Application for a Non-Material Amendment Following a Grant of Planning Permission

Land to the North of Water Lane development site (see A/256/21/RES)

Approval of reserved matters following outline consent A/248/21/PL for the erection of 525 No residential dwellings with associated parking, landscape, play areas & public open space.

A/256/21/RES

Detached Double Car Port

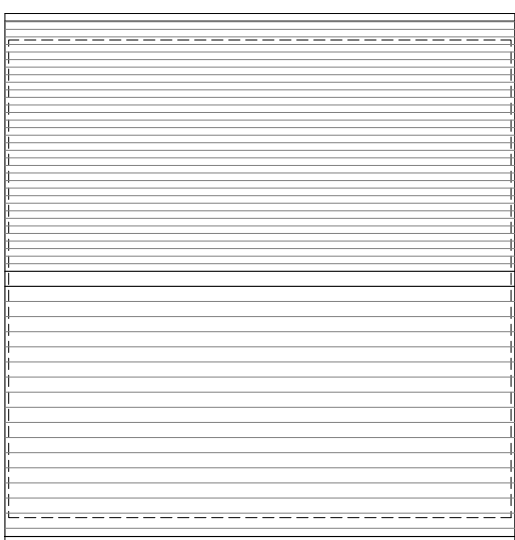
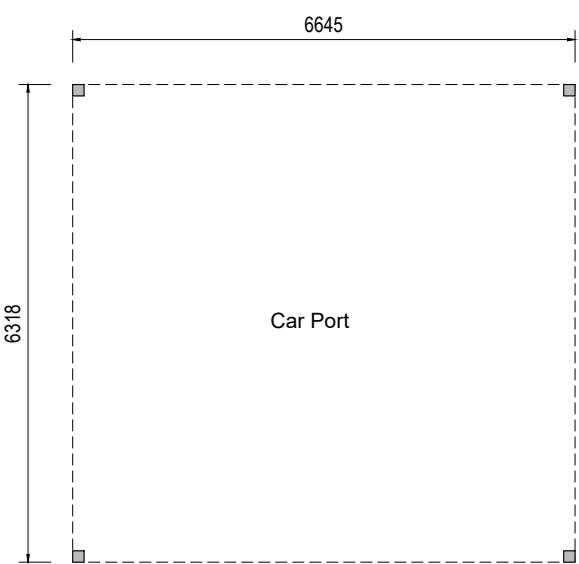
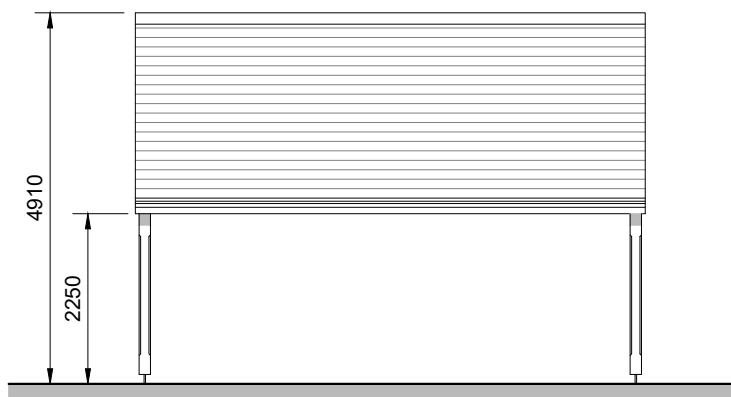
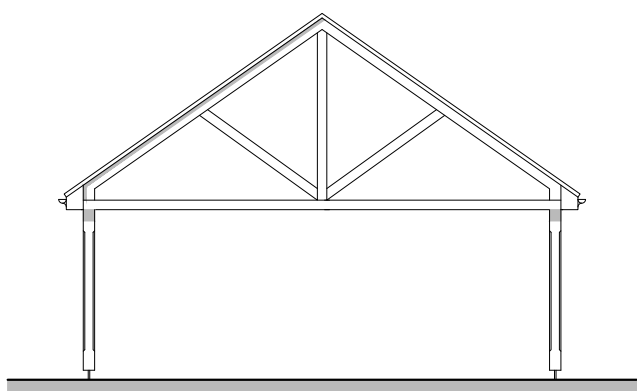
Amendment of approved single and double car ports on plots 507, 523, 524 to single (507) and double (523, 524) garages respectively.
